# KITTITAS COUNTY

### MEMORANDUM

TO: Jeff Watson  
FROM: Christina Wollman, Planner II *CW*  
DATE: June 8, 2010  
SUBJECT: Kittitas County Fire District #7 PF-10-00002

INTERIM PHASE IA BUILDING
 PHASE IA, IB, AND PHASE II AS MAY BE INDICATED
 (see building plans for information)
SITE DEVELOPMENT PLAN
 SCALE : 1" = 20'-0"

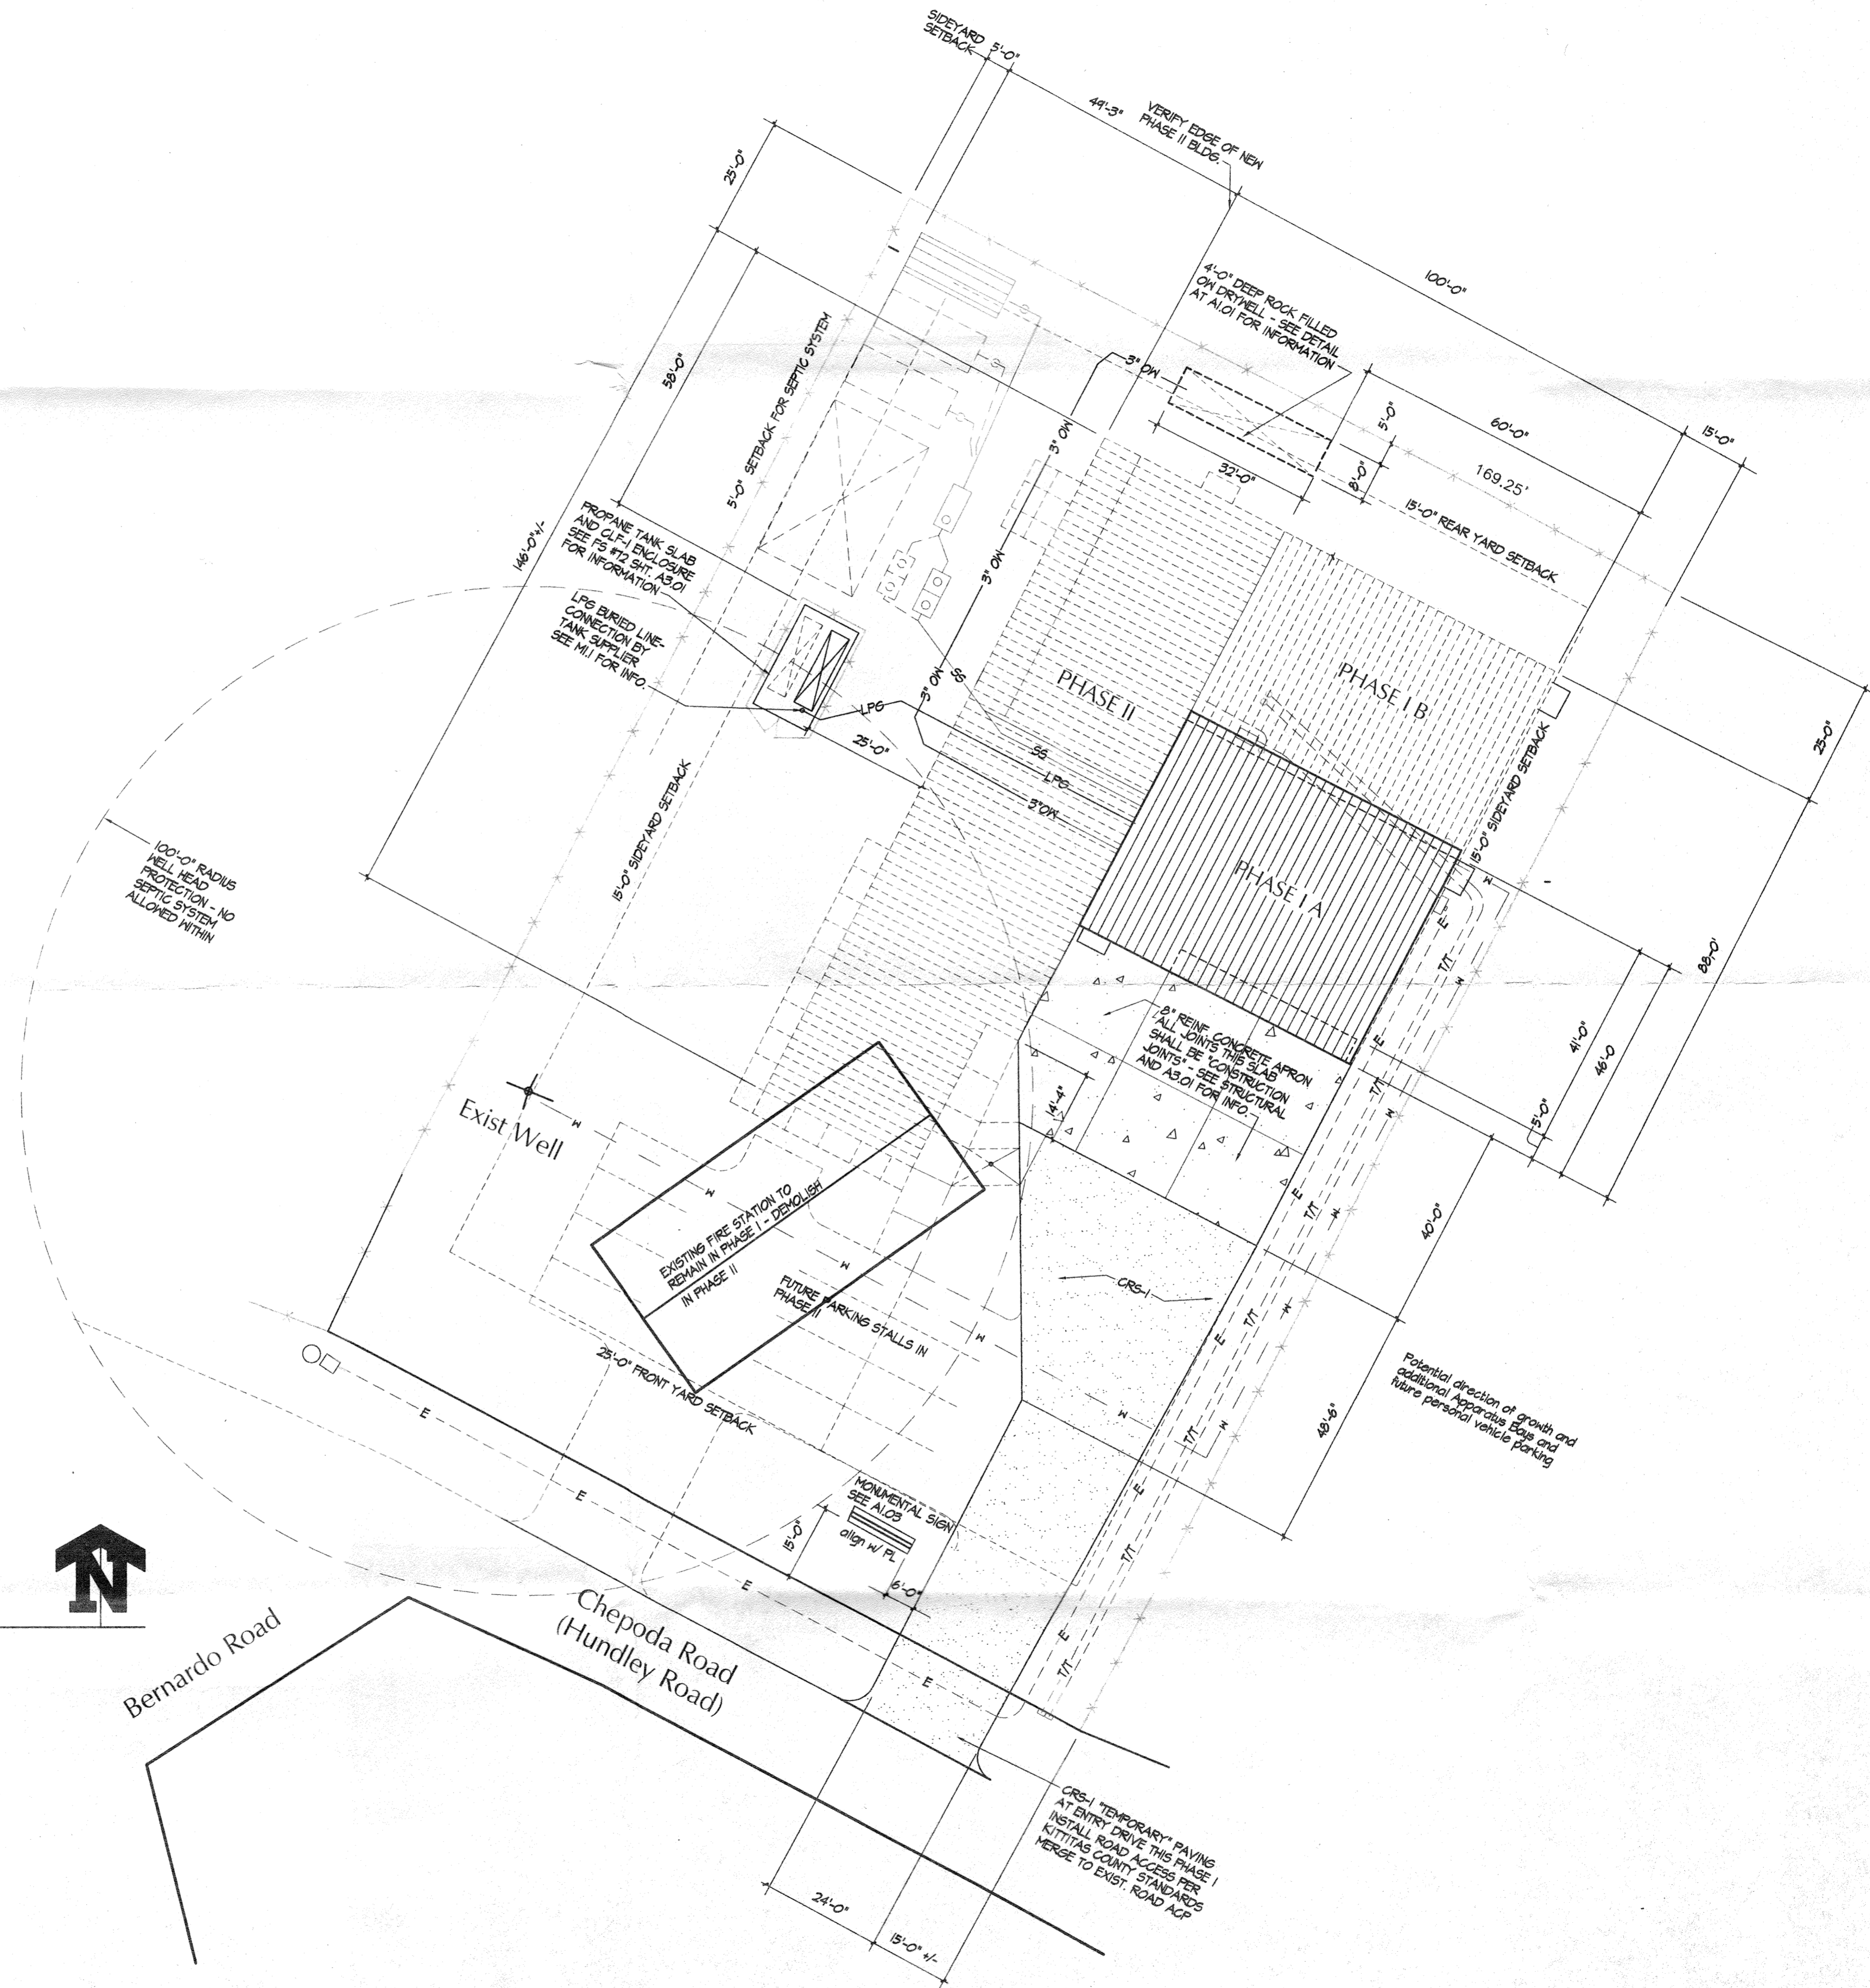
- A. Access: Access to the proposed shall be constructed as required by Kittitas County Road Standards.
- B. Access Permit: An approved access permit will be required from the Department of Public Works prior to creating any new driveway access or performing work within the county road right of way.
- C. Addressing: Contact the Kittitas County Rural Addressing Coordinator at (509) 962-7523 to obtain addresses prior to obtaining a building permit. A parcel cannot receive a building permit or utilities until such parcel is identified with a 911 address.
